Application No: AW/366/21/HH
Site Address: 7 Cedar Close Aldwick PO21 3BE
Description of works: Erection of single storey rear extension with first floor juliet balcony, installation of 2 x side dormers following the demolition of existing rear conservatory.

Thank you for your internet representation made on 23rd November 2021 which has been recorded as an objection with the comments as follows:

TITLE: PROPOSED ELEVATIONS

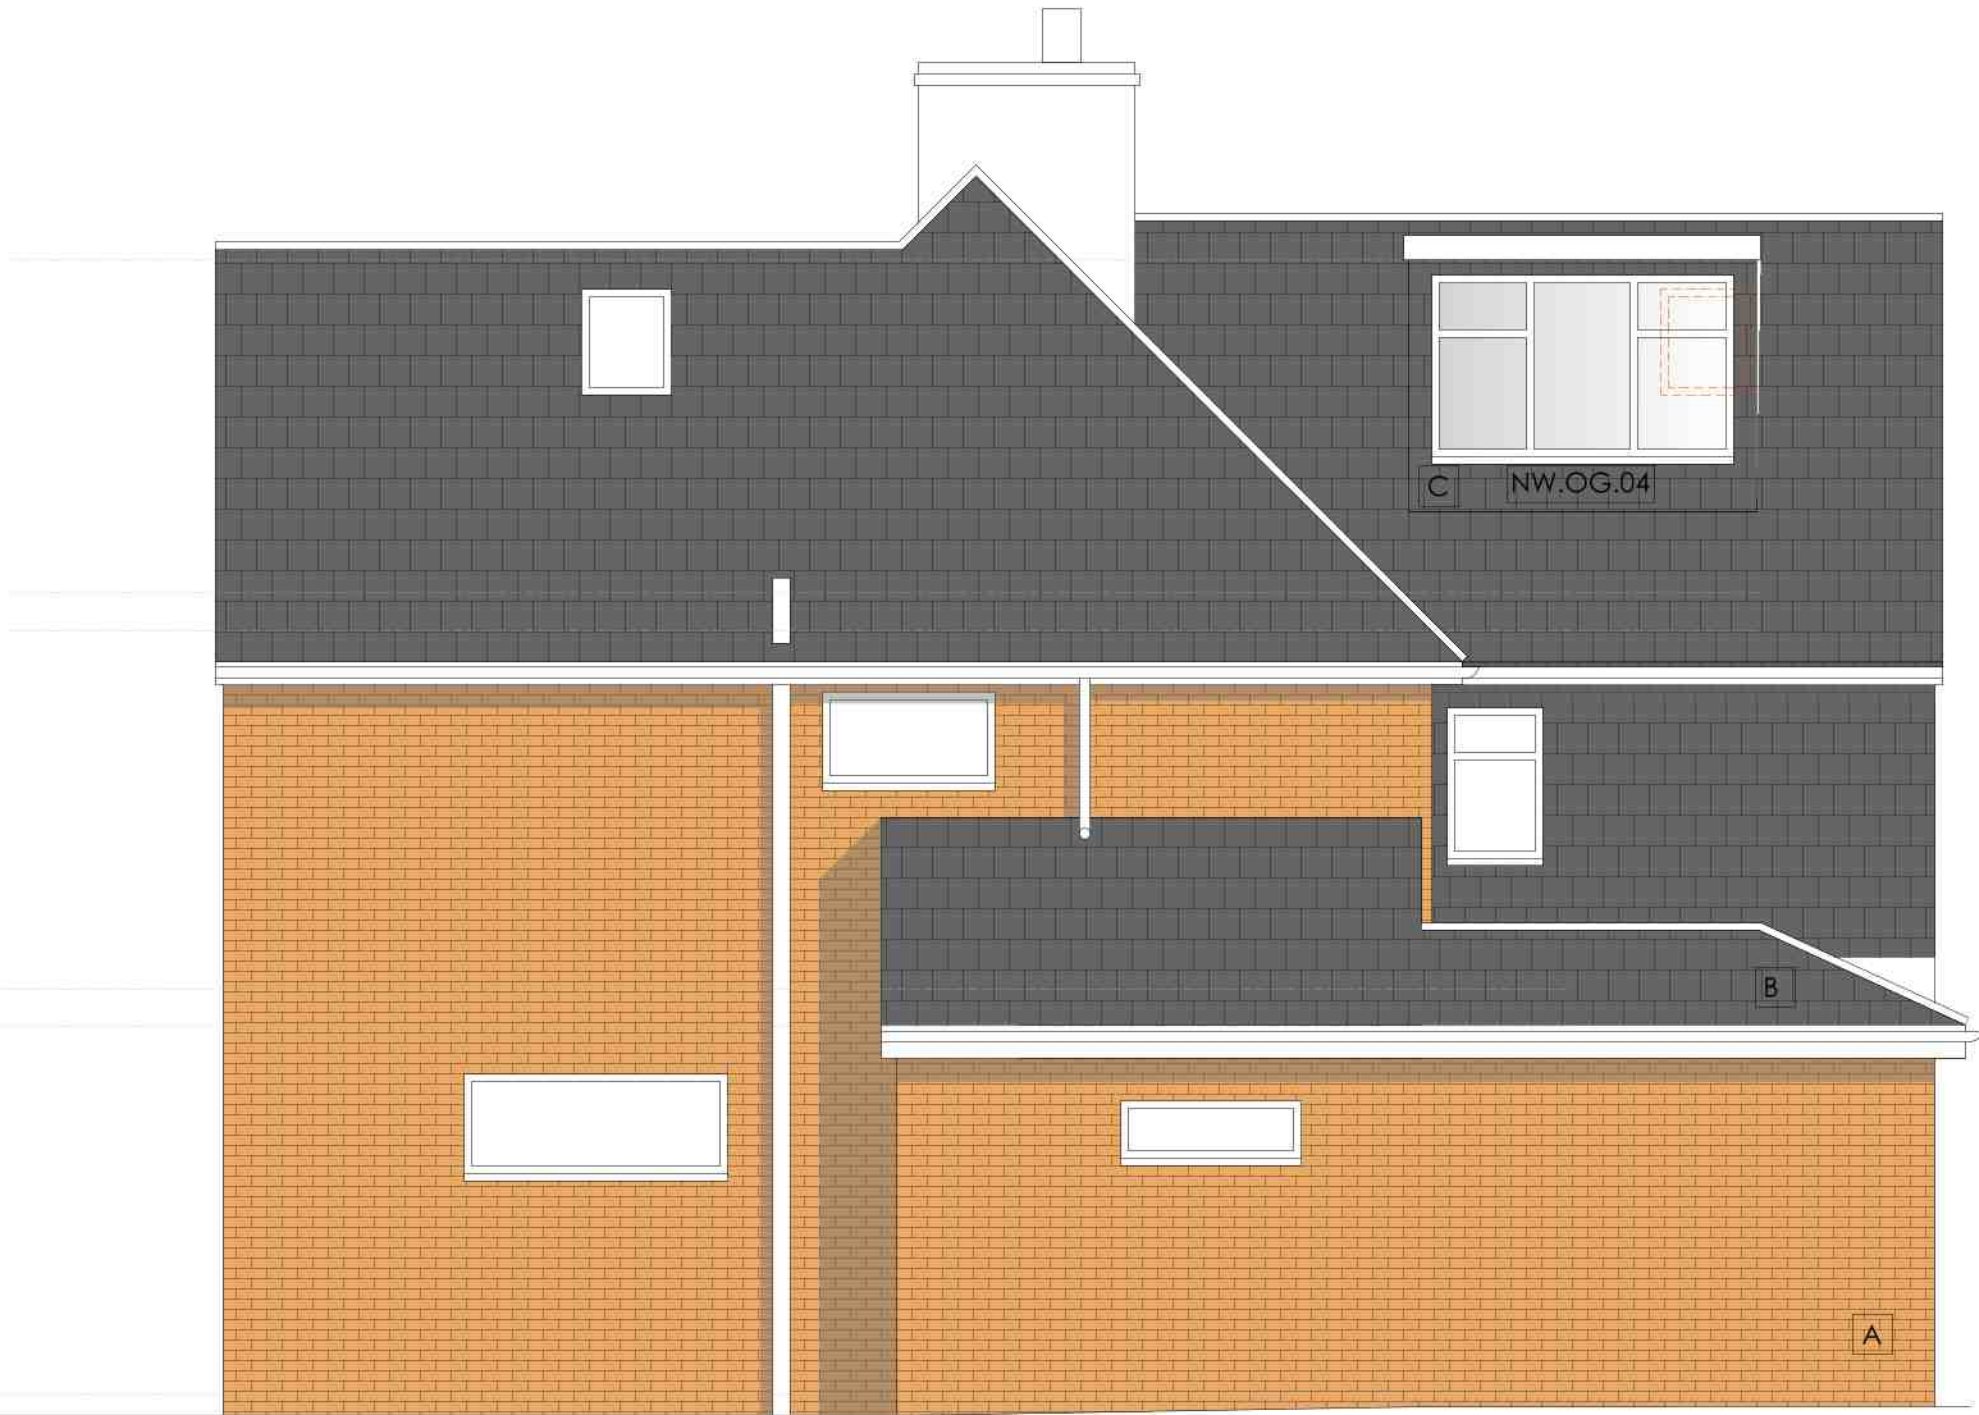
Members strongly objected to the application on the grounds that the
Juliet balcony would result in an adverse overlooking effect on
neighbouring properties. Therefore, Members agreed that the proposed
application was in direct conflict with Policy D DM4 (c) of the Arun Local
Plan 2011-2031 and with the Parish Design Statement (p 54)
